Demolition of existing dwelling & erection of a 62 bedroom care home (C2 Residential Institution) with car park, landscaped gardens & access from Roundstone Lane (resubmission following A/51/18/PL).

Pound Place Roundstone Lane Angmering

Thank you for your internet representation made on 12th August 2019 which has been recorded as '**an objection**' with the comments as follows:

TREE PROTECTION PLAN

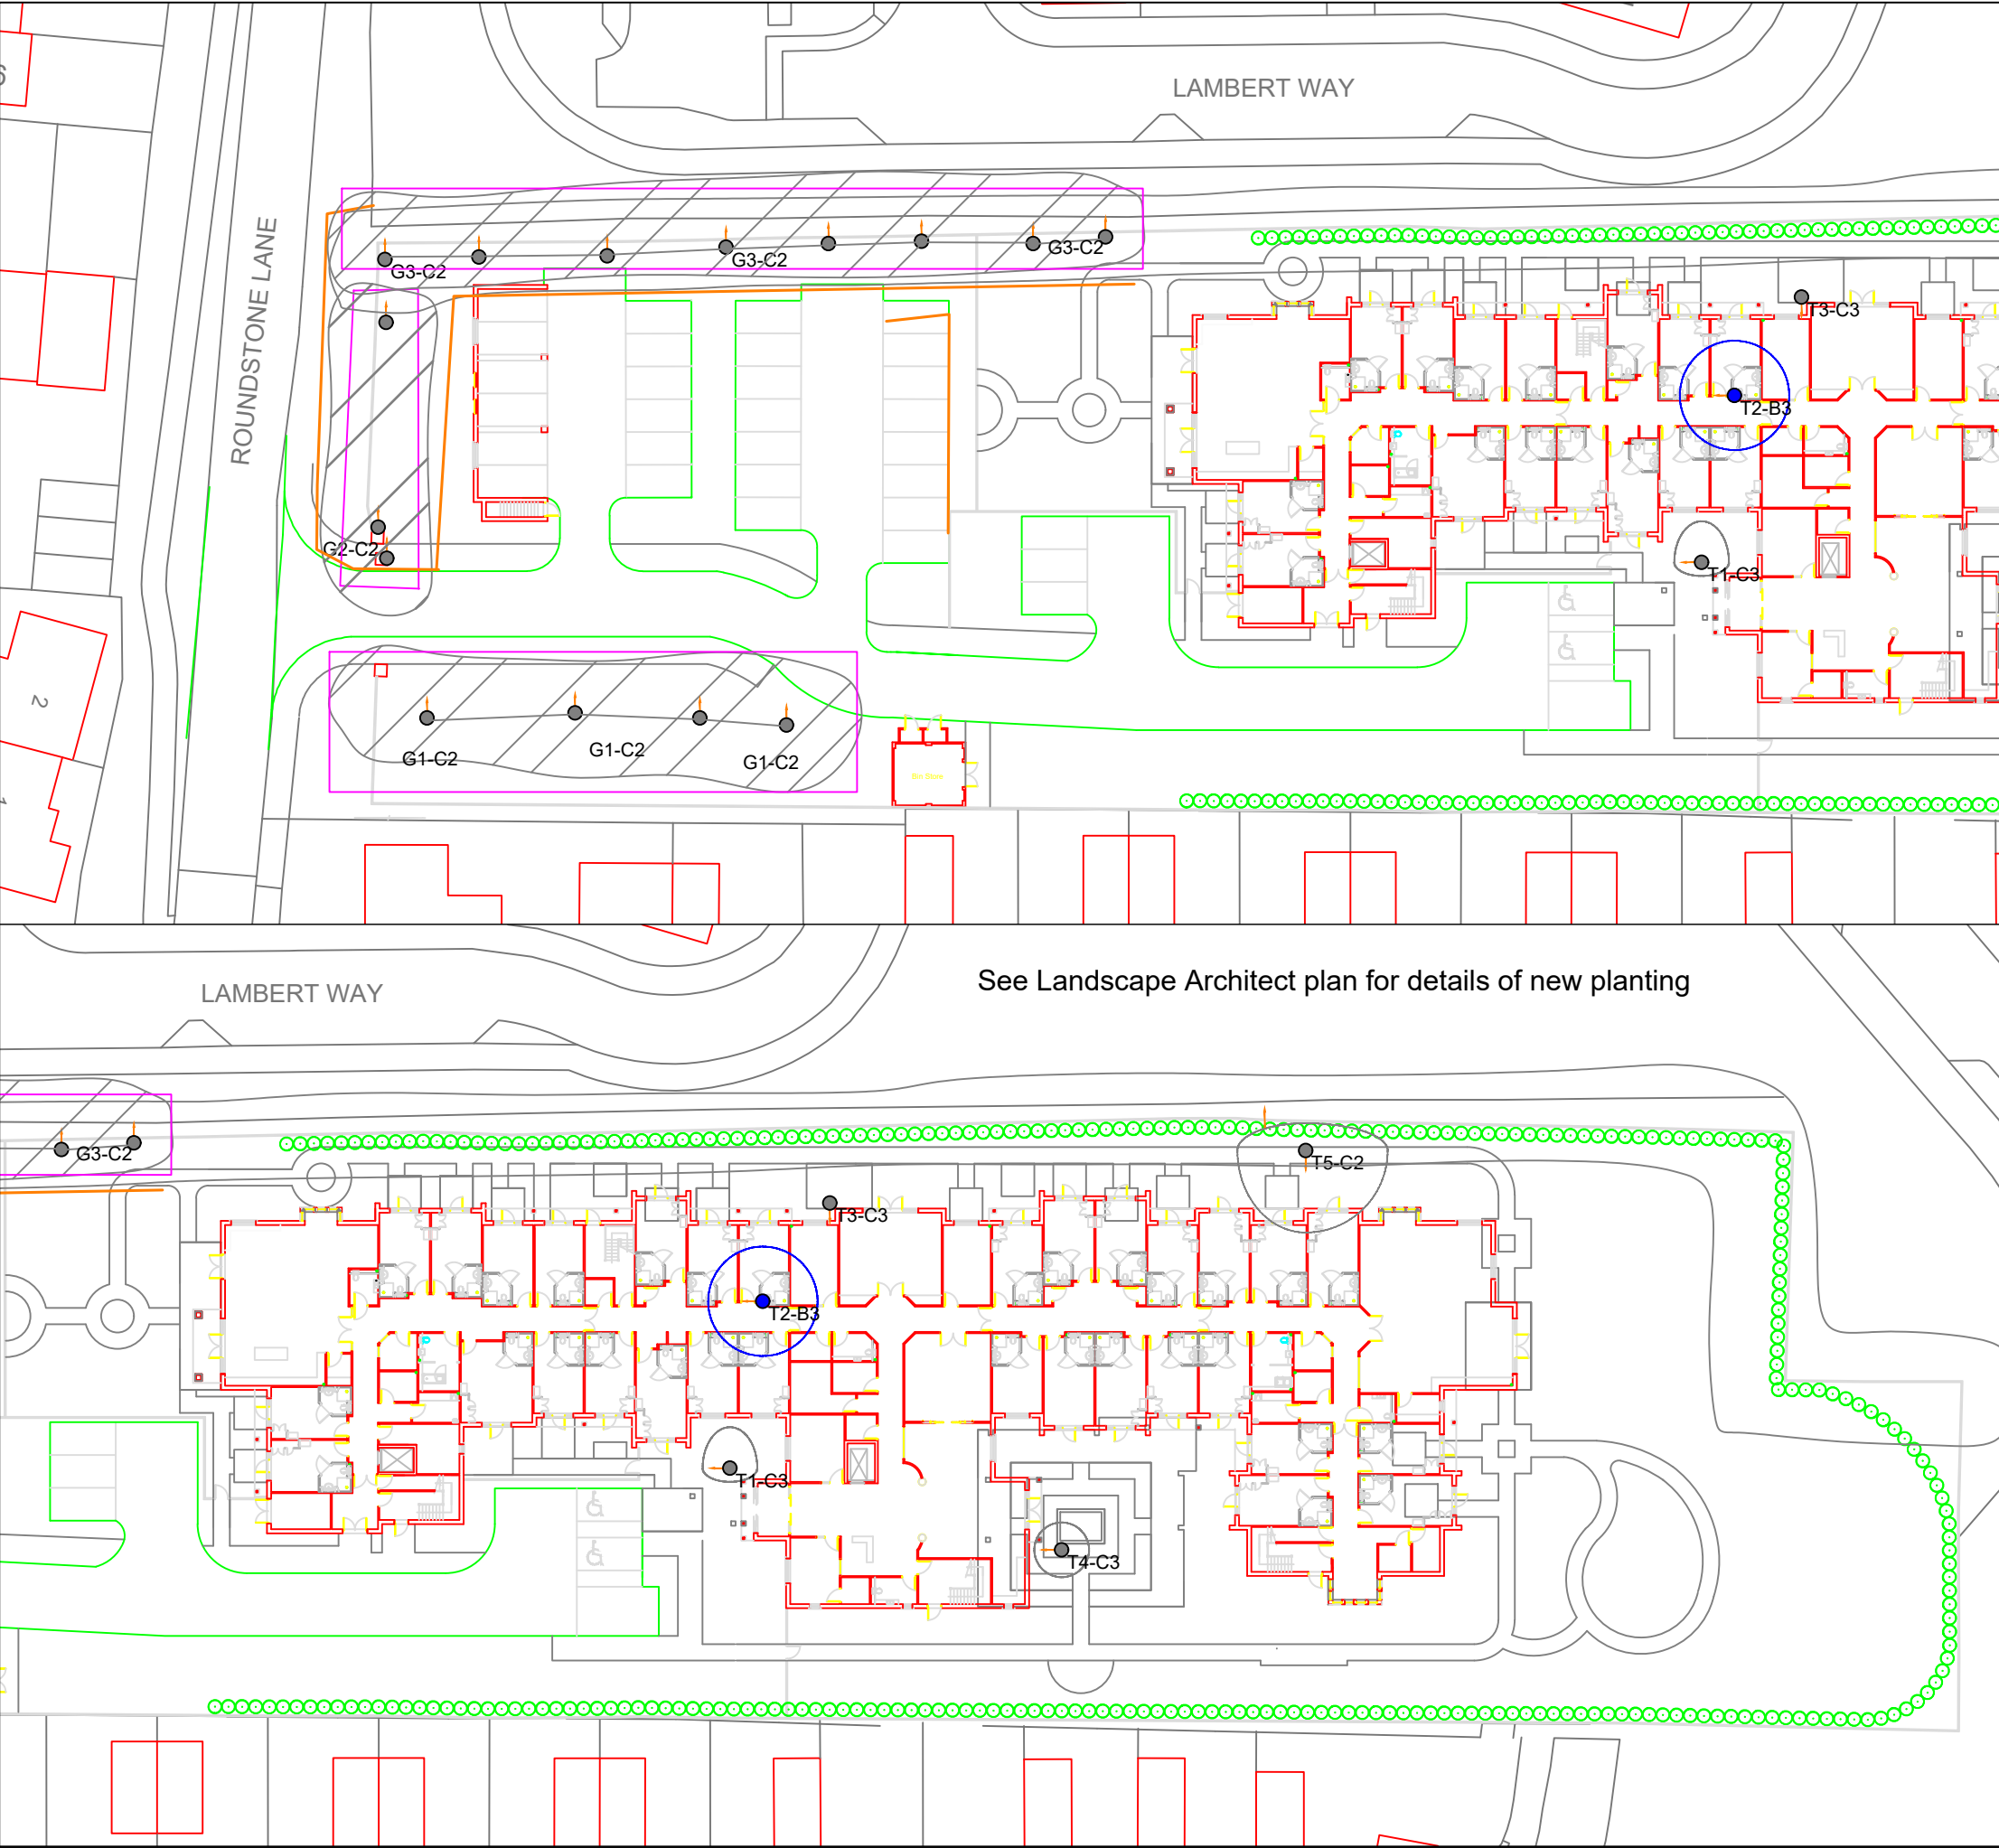
In the tree officer's report dated 17th July he approves the retention of the superior group of trees on the western border with Roundstone Lane. On the amended plan, these trees seem to have been removed. The trees on this boundary are of particular importance and should be retained as they provide a) amenity value as a group contributing to the green character of the area; b) shield the large incongruous structure from the otherwise residential character of the area; c) provide a barrier to the additional noise that will be generated from the establishment; and d) also shields the Bramley Green development visually from the South Downs at Highdown, confining it to glimpses of roof tops.
